Subject: Copi Mineral Sands Project (SSD-41294067) – Request for Additional Information

Attachment 1 – Additional Information Required

Figure 3.2
AMENDED MINE SITE LAYOUT

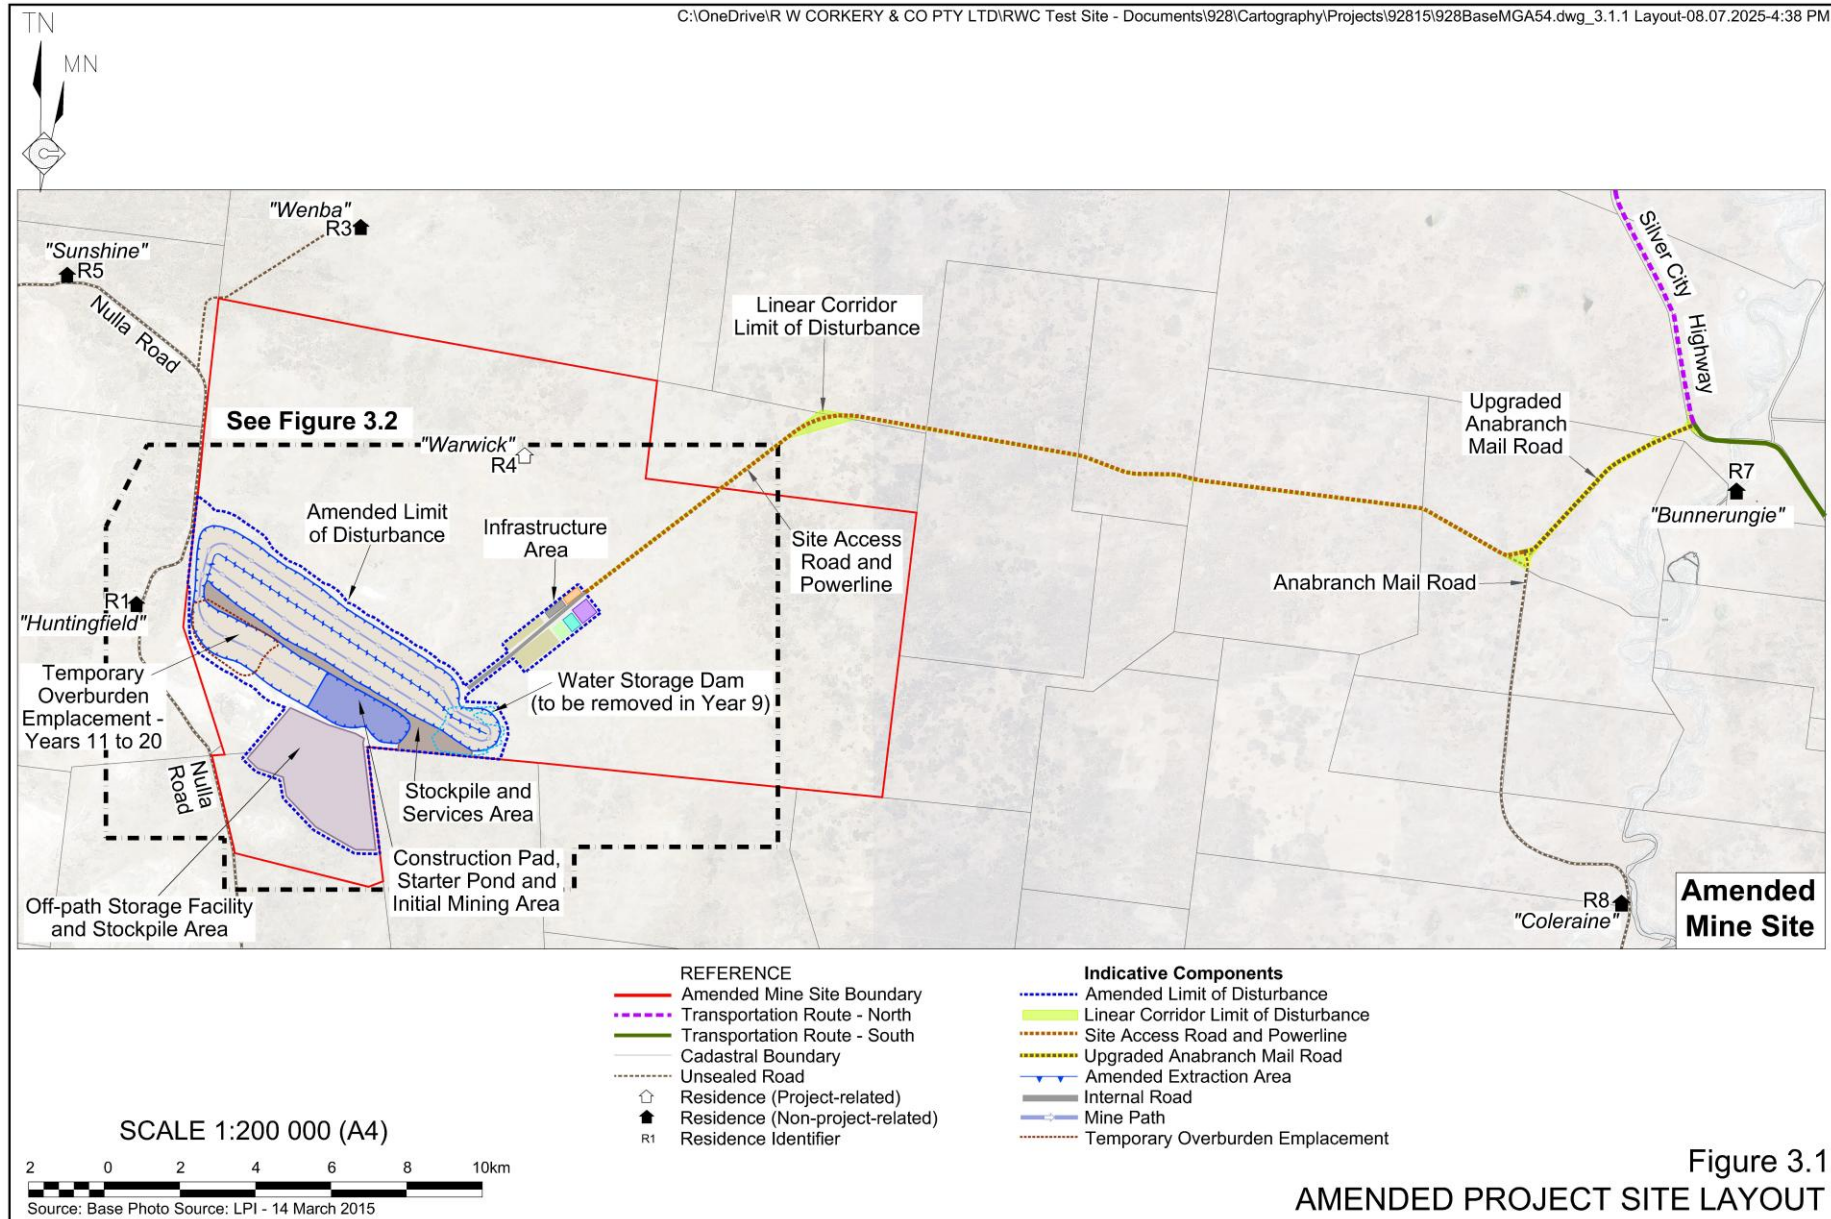
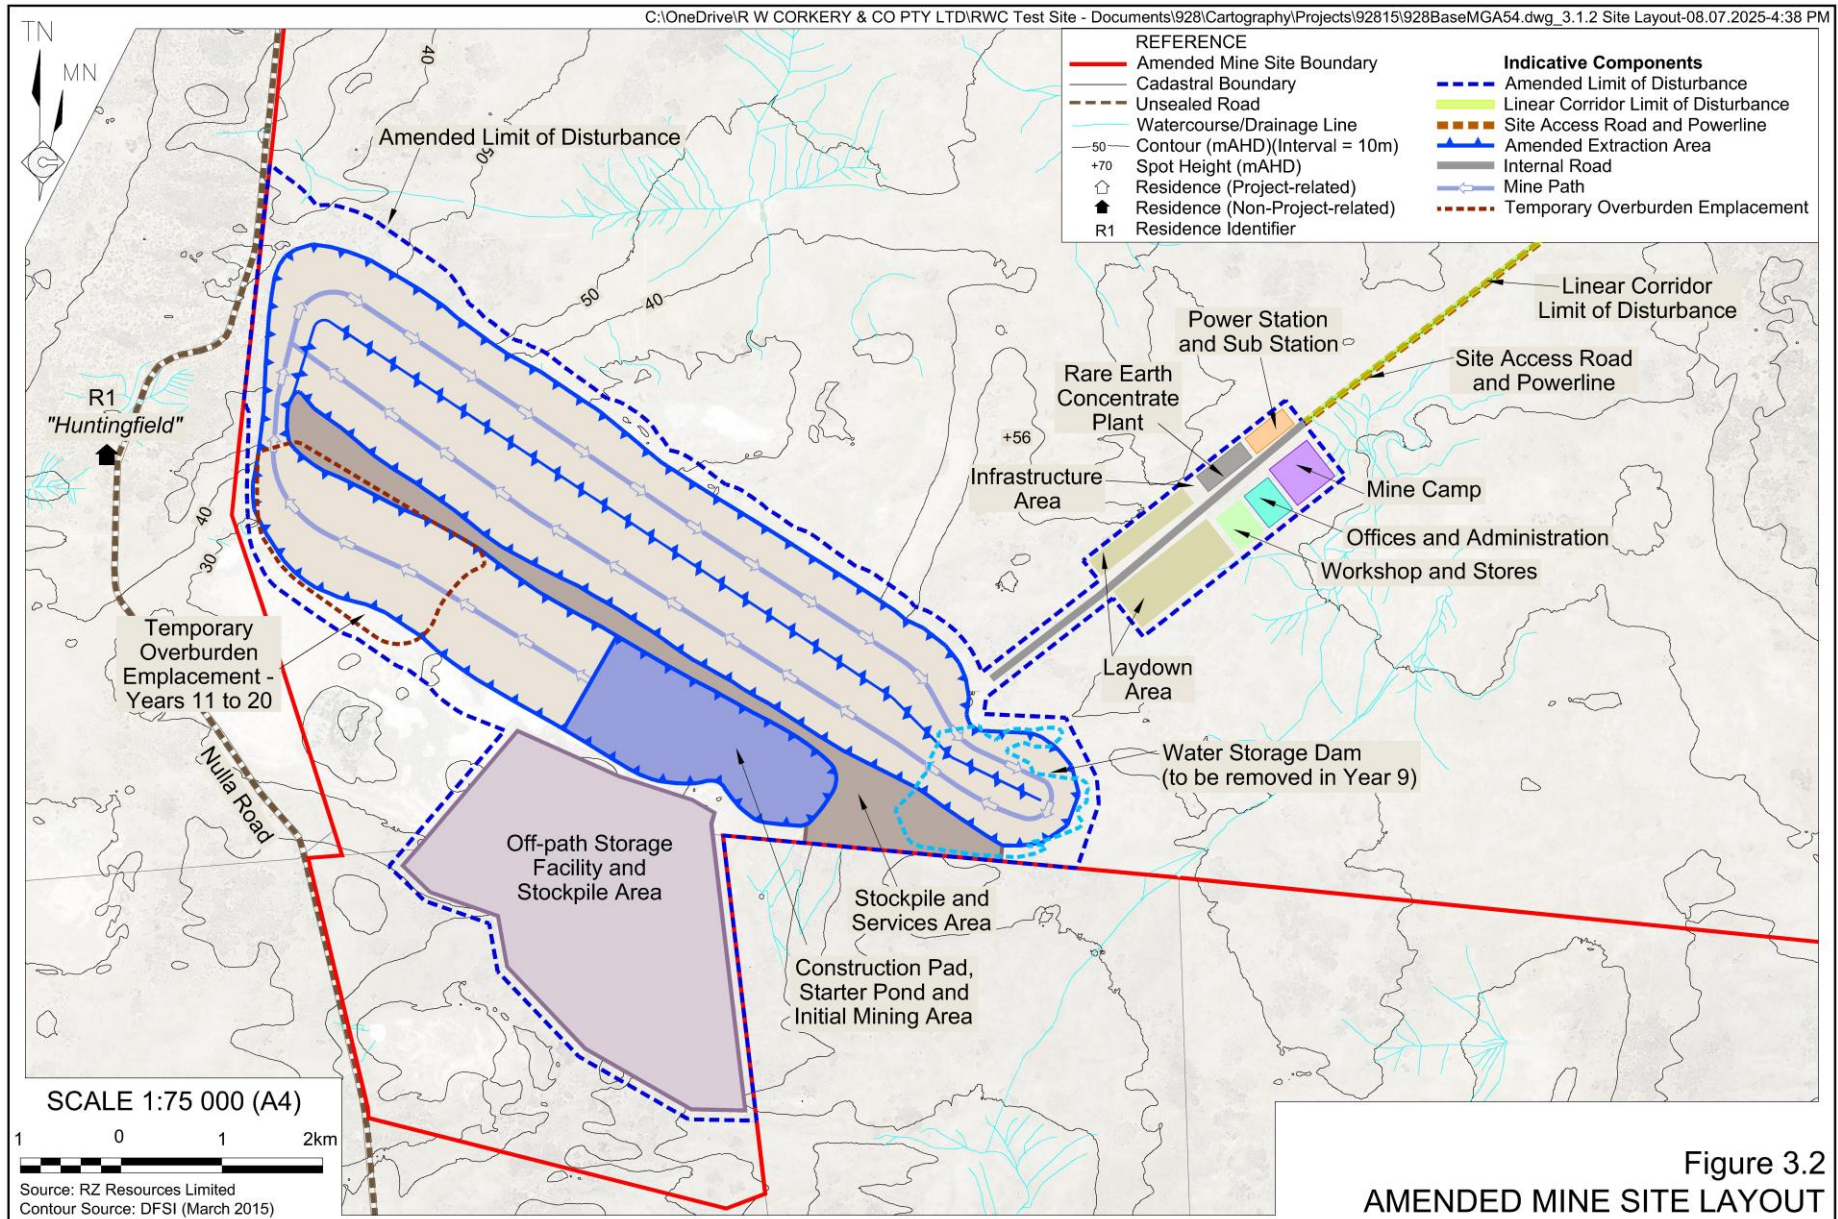
Figures	Please provide figures that detail a side-by-side comparison of the project as described in the EIS and as described in the Amendment Report. One figure for the Mine Site, and one figure for the project as a whole (including the infrastructure corridor).
